- 1 OF 13 - SITE PLAN & DETAILS, PROJECT INFORMATION, DRAWING INDEX
- 2 OF 13 - GRADING & EROSION COVER SHEET
- 3 OF 13 - GRADING & EROSION CONTROL PLAN
- 4 OF 13 - GRADING & EROSION DETAIL
- 5 OF 13 - GRADING & EROSION DETAIL
- 6 OF 13 - UTILITY SERVICE COVER SHEET
- 7 OF 13 - UTILITY SERVICE PLAN
- 8 OF 13 - LANDSCAPE DETAILS
- 9 OF 13 - LANDSCAPE DETAILS
- 10 OF 13 - PHOTOMETRIC PLAN
- 11 OF 13 - PHOTOMETRIC PLAN
- 12 OF 13 - DP BUILDING ELEVATIONS
- 13 OF 13 - DP BUILDING ELEVATIONS

Markup Summary

LOT 2, CLAREMONT BUSINESS PARK
PL. NO. 1A
SAC08-01-027
CB CARD-0
0.2789 SF (2.45 ACRES)
VACANT
ZONE X MAP NO. 0804-C7350 P.
DATED MARCH 11, 1991
10,000 SF
B-3-C
1-5
NONE
NONE
50,245 S.F.
20,000 (2 bldg)
OFFICE/WAREHOUSE
8% - IV PHASE I 14%
34% - IV PHASE II 54%

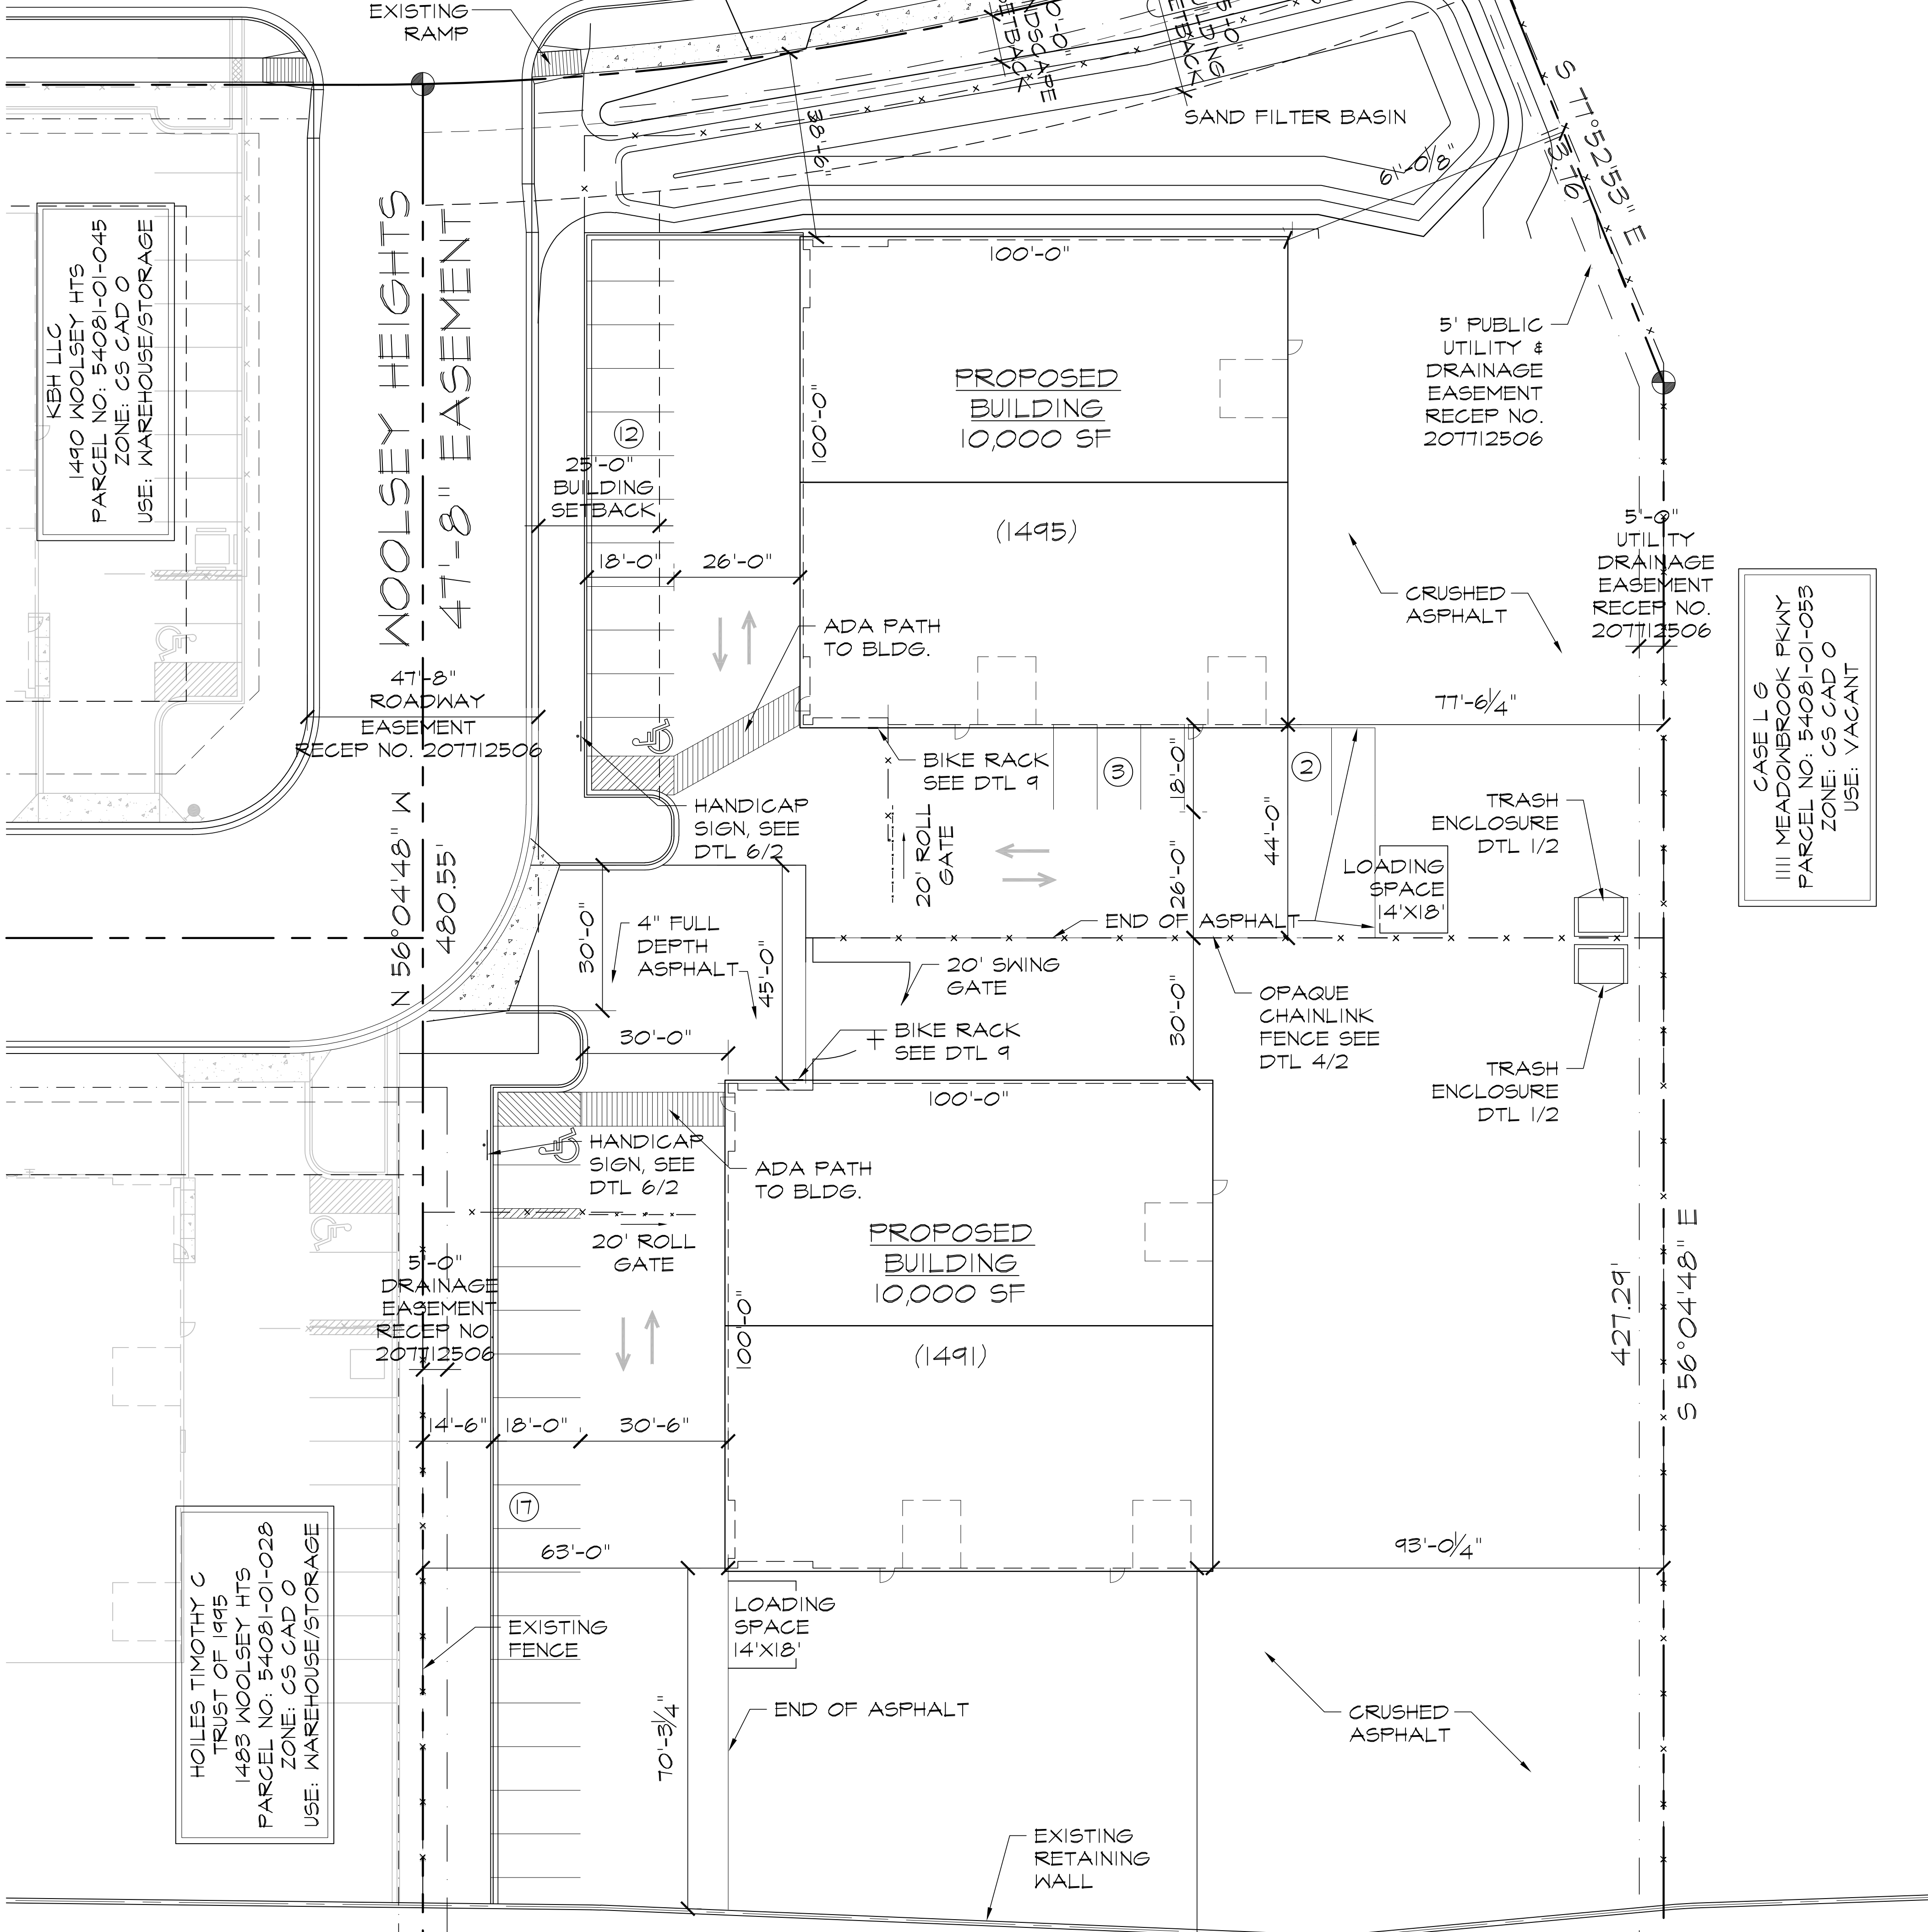
Show the 5' public utility and drainage easement along this property line as indicated on the Plat.

Indicate whether this is a new or existing sidewalk

Provide ADA note

Label the water quality facility as a sand filter basin per the drainage report.

Locate the sidewalk 6" away from the property line per ECM criteria

Include reception number of utility and drainage easements, typical.

Label the proposed loading areas for each building and provide screening where visible from a public road or residential area.

-Revise site data and parking calculations to reflect what is proposed on site. It currently appears to only include one building and half the parking.

- Parking ratio for offices is 1/200 rather than 1/300 shown.

- Provided Bike Parking calculations (required and proposed)per LDC 6.2.5(F).

(149)
Label location of
proposed bike
parking to serve
each bldg.

All parking must be on paved surfaces

loading space size should be 14 x 18 per Table 6-6 in LDC.

Setbacks for side and rear are 25' if located along the edge of the zoning district. This applies to the East property line adjacent to 24.

Will any edging or other means be provided to prevent erosion of crushed asphalt into pond?

Label any dumpster locations and/or trash handling areas for each bldg.

Ensure that the floorplans shown on the floorplan sheet match those shown on this sheet. Same level of detail is not needed but the interior wall locations should match.
